The Drax Power (Generating Stations) Order

Schedule of Changes

Drax Repower Project

Applicant: DRAX POWER LIMITED
Date: January 2019
Document Ref: 8.2.6
PINS Ref: EN010091

Figure 1.1 - Extent of Mitigation Covering a 1 km Radius from the Proposed Scheme

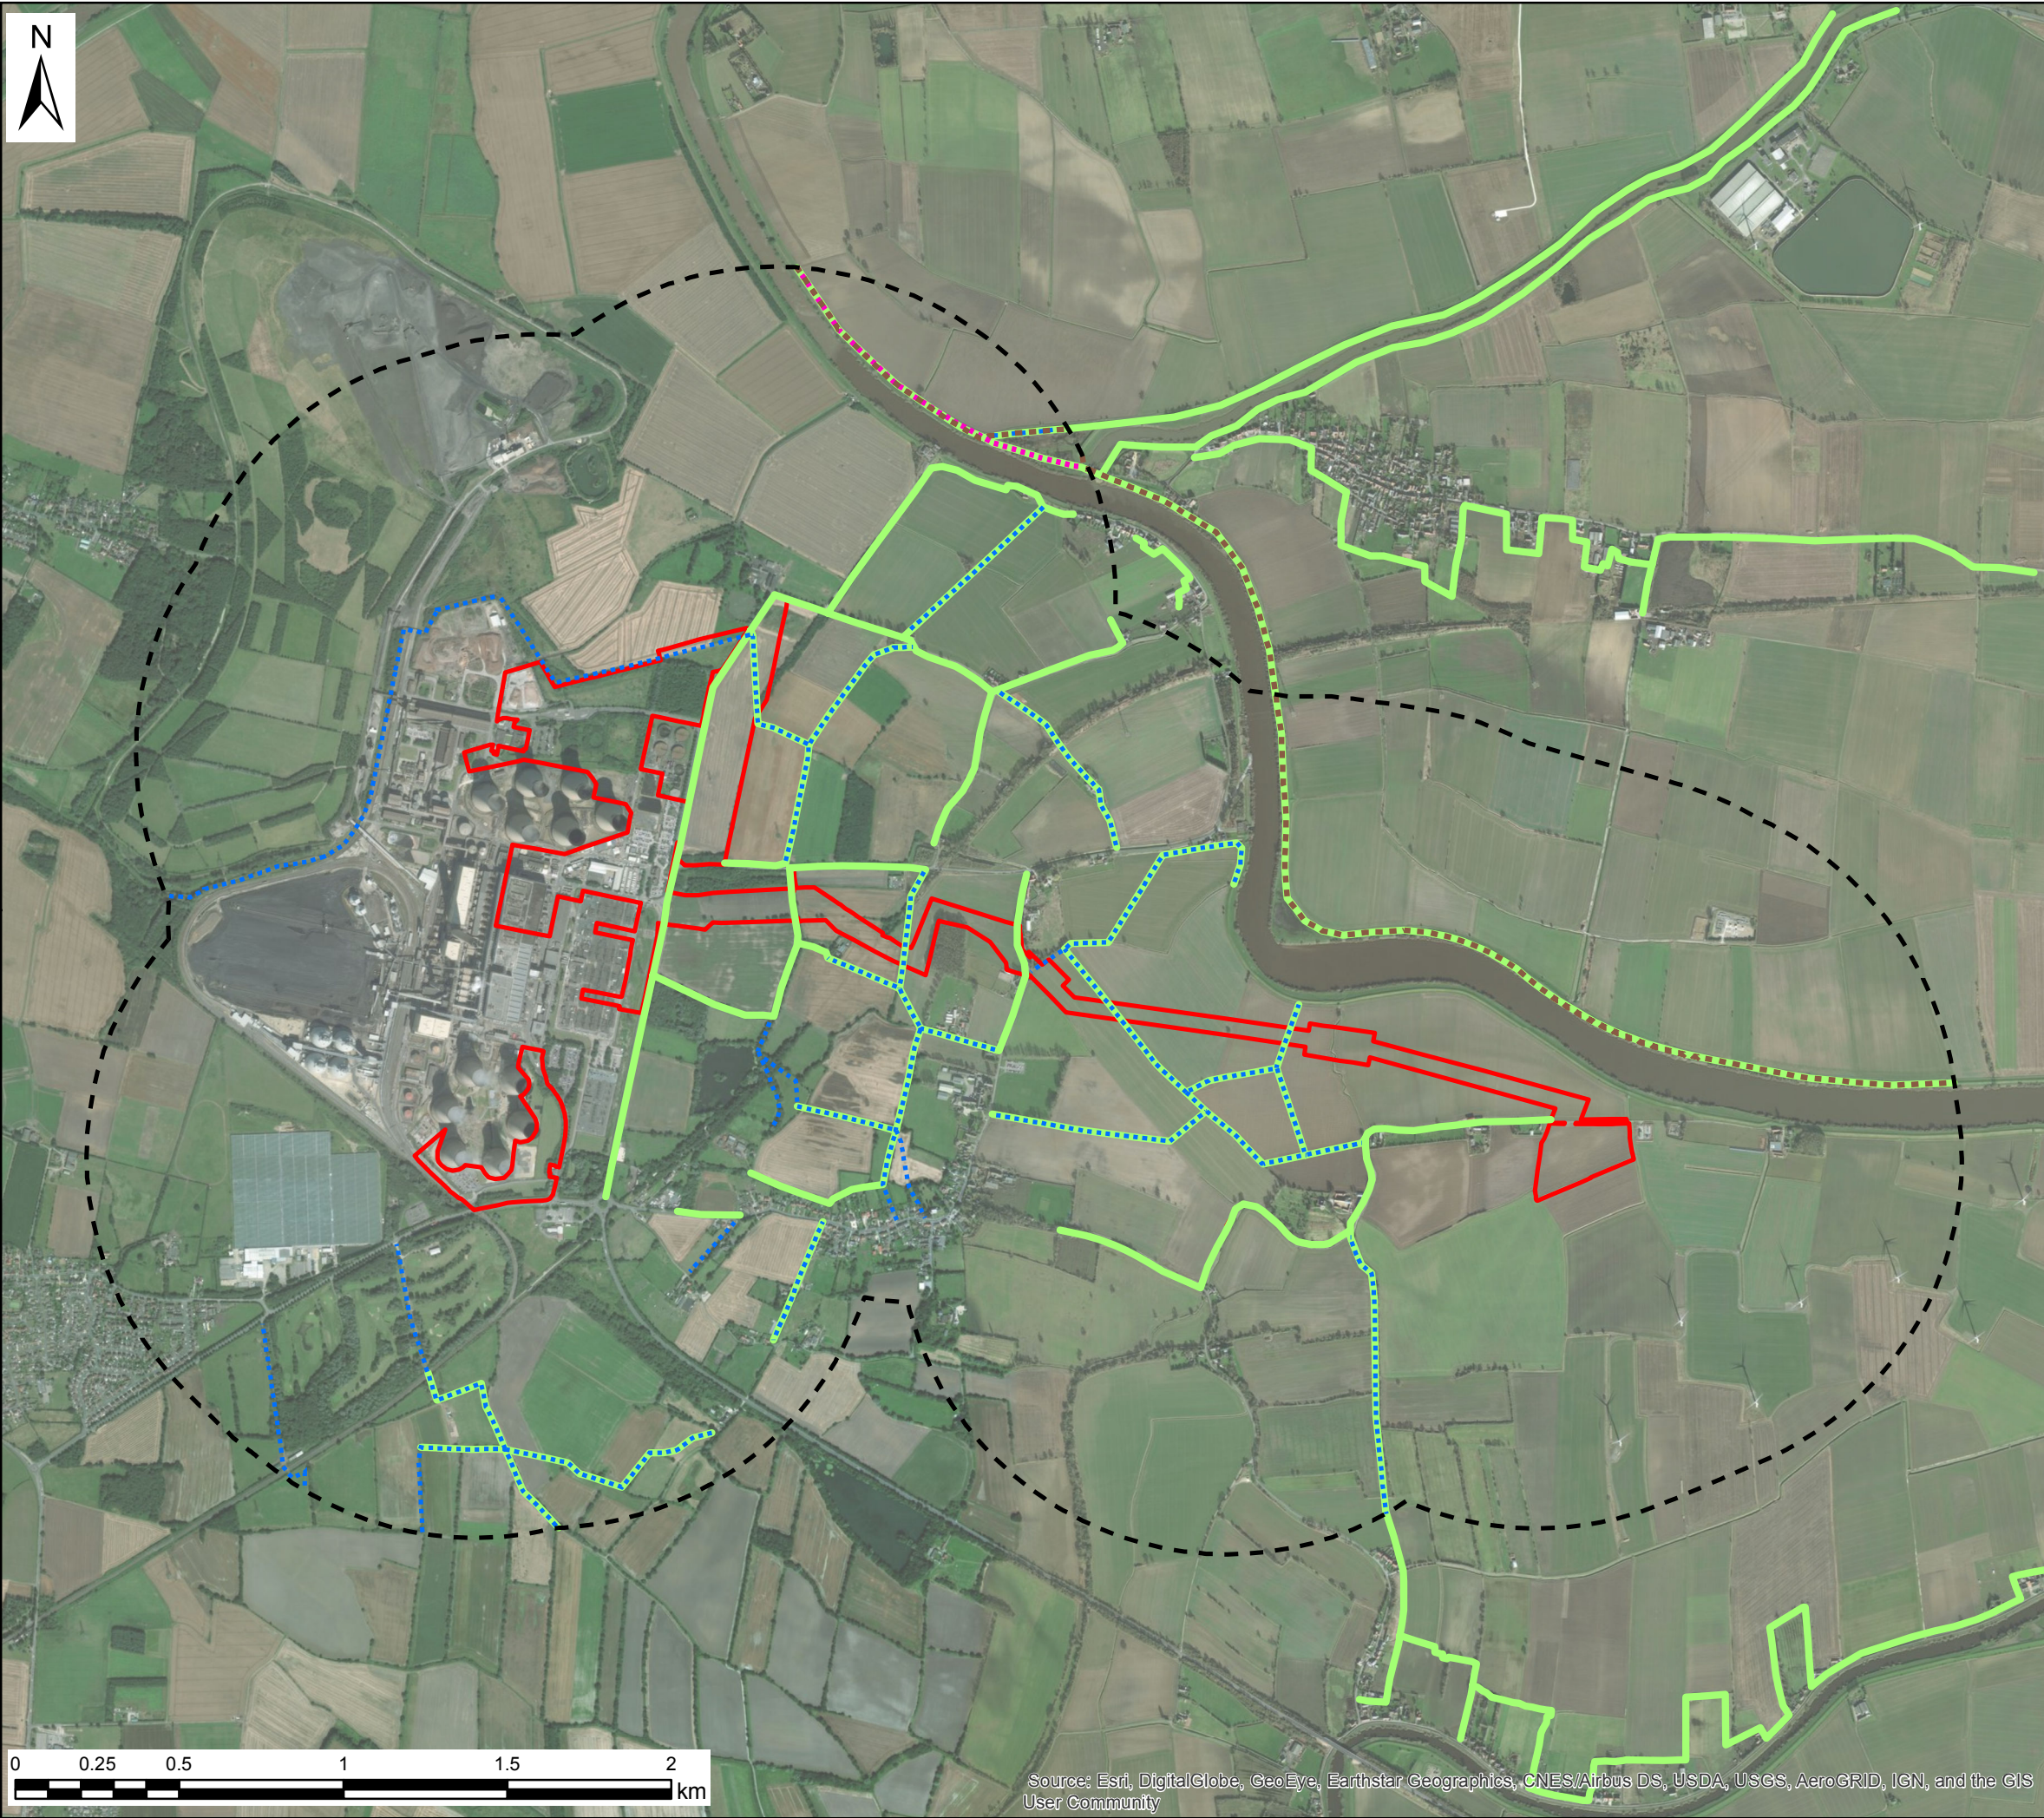
Reference	Change	Reason for Change
Reference in Section 1 and 4 and substitution of Figures 1.1 and 1.4 in Appendix 1 and 2 respectively	Revisions to paragraph 4.2.3 and 4.3.2 Revisions to Figure 1.1 and 1.4	Based on points of clarification of text and figures in the Examining Authority's Second Written Questions.
